Jeremy Smethurst WR summary, deadline 1

Please see attached my written representation for the 28th February deadline (deadline 1).

Environmental Statement

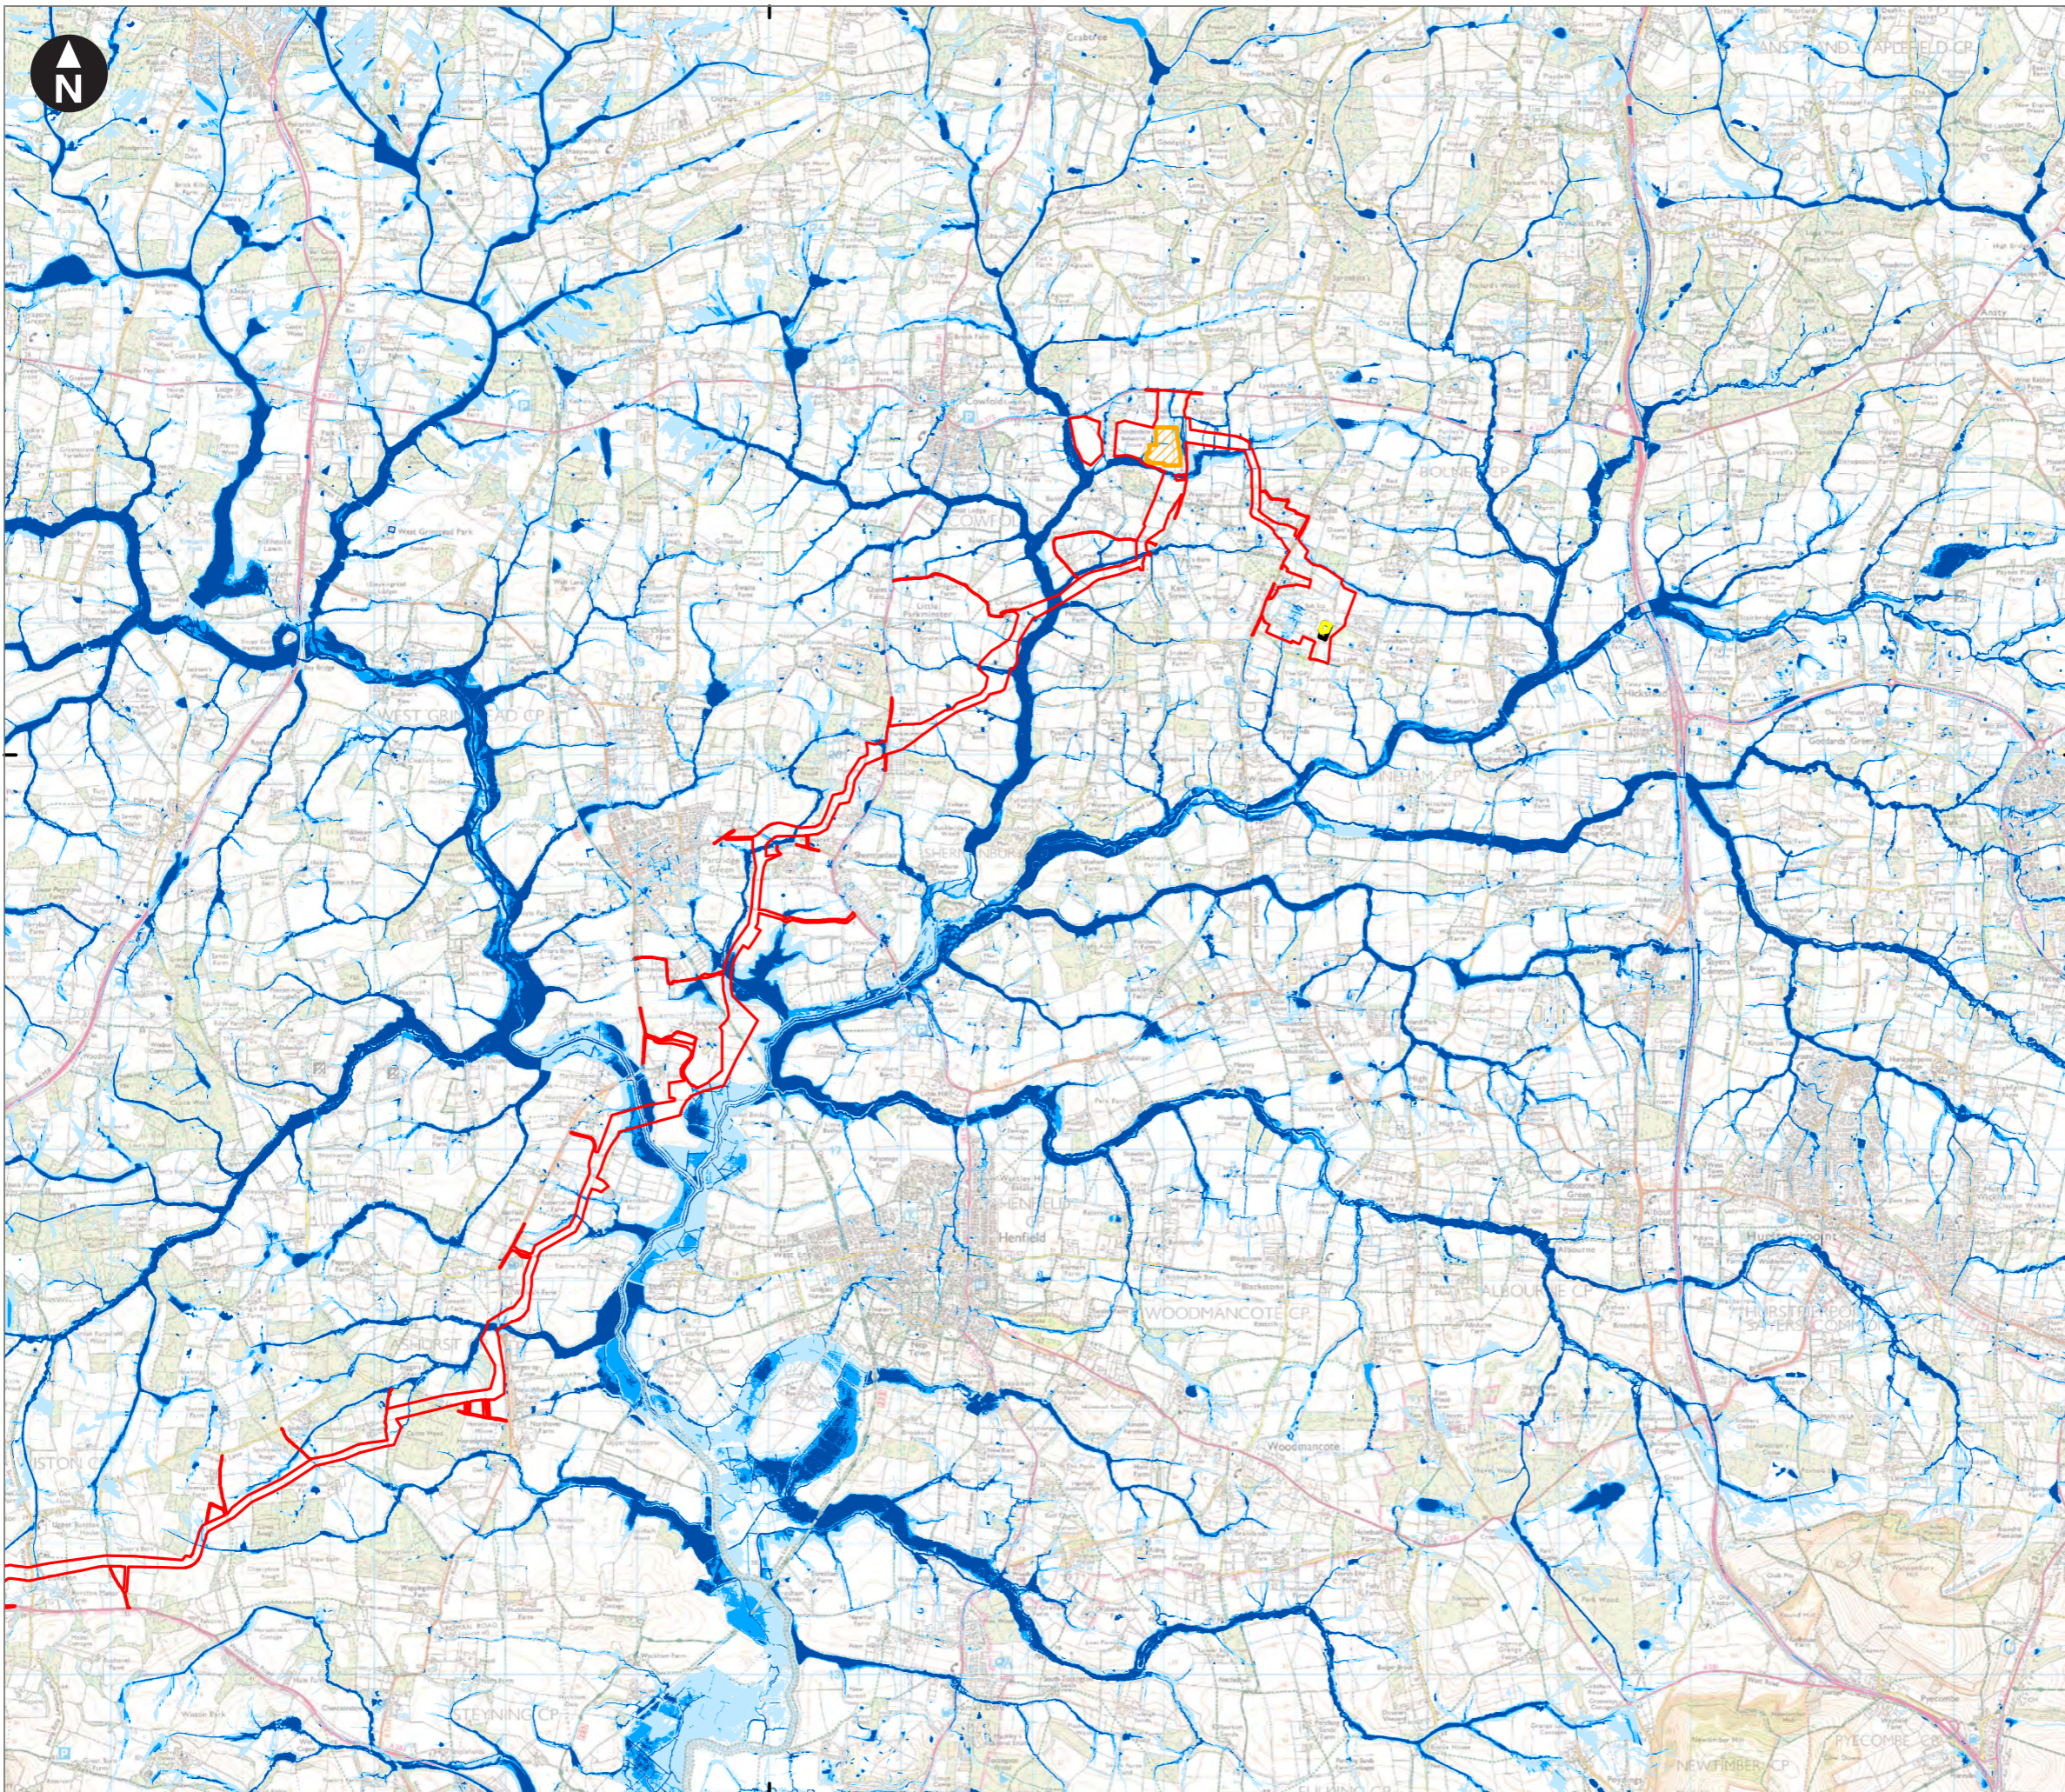
Indeed, their own map (Figure 26.2.6a) shows the risk of surface water flooding to be quite significant. Section 5.3, para 7-10 discusses the surface water flood risk on site. I dispute what is said in table 5-8; whilst this may be true for the whole Oakendene site, much of the highest risk areas ie 9,5% of the site, lies within the actual substation footprint (see map) There are too many 'it is thought that' statements-actual consultation would have cleared this up easily.

Yet even so, they admit in paragraph 6.5.3: *“Regions of high risk of surface water flooding are anticipated within the onshore substation footprint, coincident with several surface water flowpaths which drain from north to south across the site. In the absence of appropriate mitigation, aspects of the onshore substation and associated infrastructure may be at risk of flooding from both surface water run-on and run-off.”* However, their Outline Drainage Plan does not adequately address this.
